**Proposed Roundabout Access to Graven Hill and
Wretchwick Green London Road Bicester**

20/01830/F

Proposal: Proposed roundabout junction

EXECUTIVE SUMMARY OF PROPOSALS AND RECOMMENDATION

## **A. A41 Pioneer Road Roundabout Design**

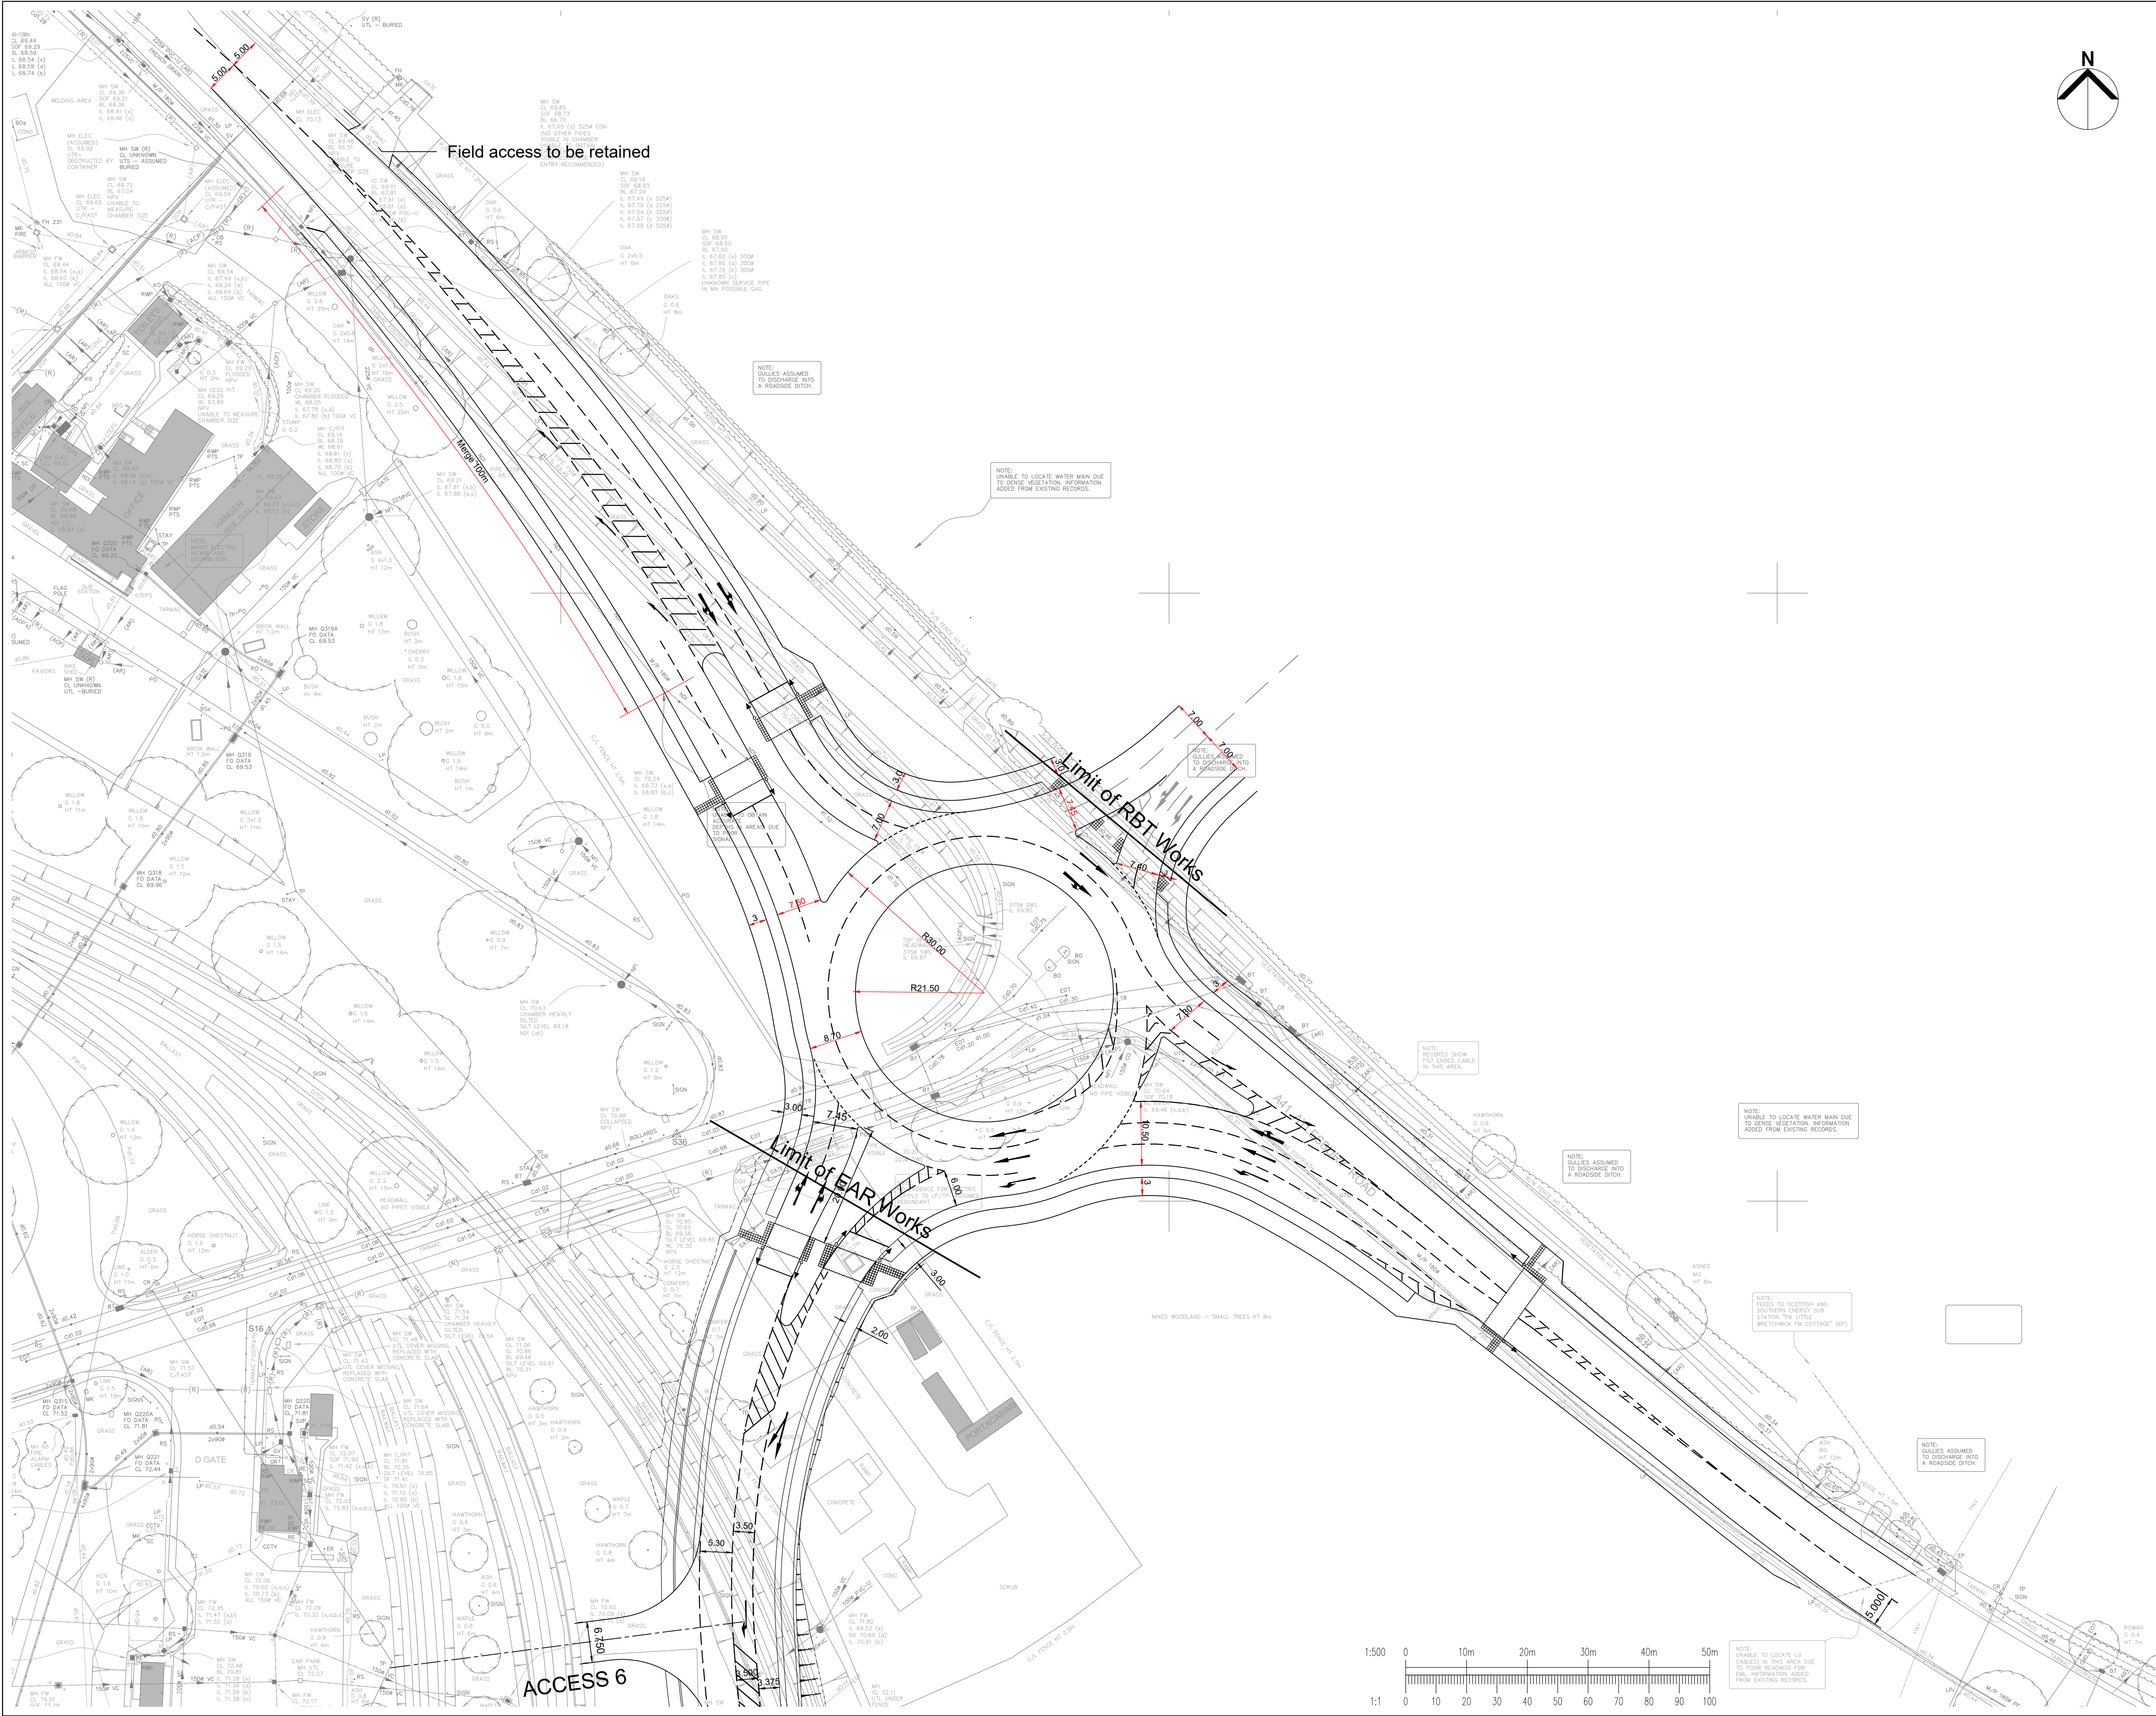
- Shared use ped/cycle facilities around the roundabout should conform to LTN 1/20 and therefore require to be segregated

- The signalised crossings should be straight across rather than staggered to minimise delay to pedestrian and cyclists.

'The form of crossing also conforms to the latest Government guidance on Cycle Infrastructure Design (LTN 1/20), which was published on 27 July 2020. However, consideration should be given to making the staggered crossing on the A41 W arm into a single phase, to minimise delay to pedestrians and cyclists. I would like to see this tested.

The width of the shared use facility at the roundabout does not conform to LTN 1/20, which requires segregation between pedestrians and cyclists. It should be amended to conform to LTN 1/20 and to be consistent with the facilities planned on the new roads leading into Graven Hill and Wretchwick Green. Sufficient space should be allowed for pedestrians and cyclists to wait at the crossings without obstructing the path of passing pedestrians and cyclists.

Officer note: Amended drawings have been submitted and officers are awaiting further comments from the Local Highway Authority.

- 9.23. The Local Highway Authority consider that both of these points can be overcome through the submission of amended drawings. Amended drawings have now been submitted to address the points raised further comments from the Local Highway Authority are awaited and an update will be provided to the committee.
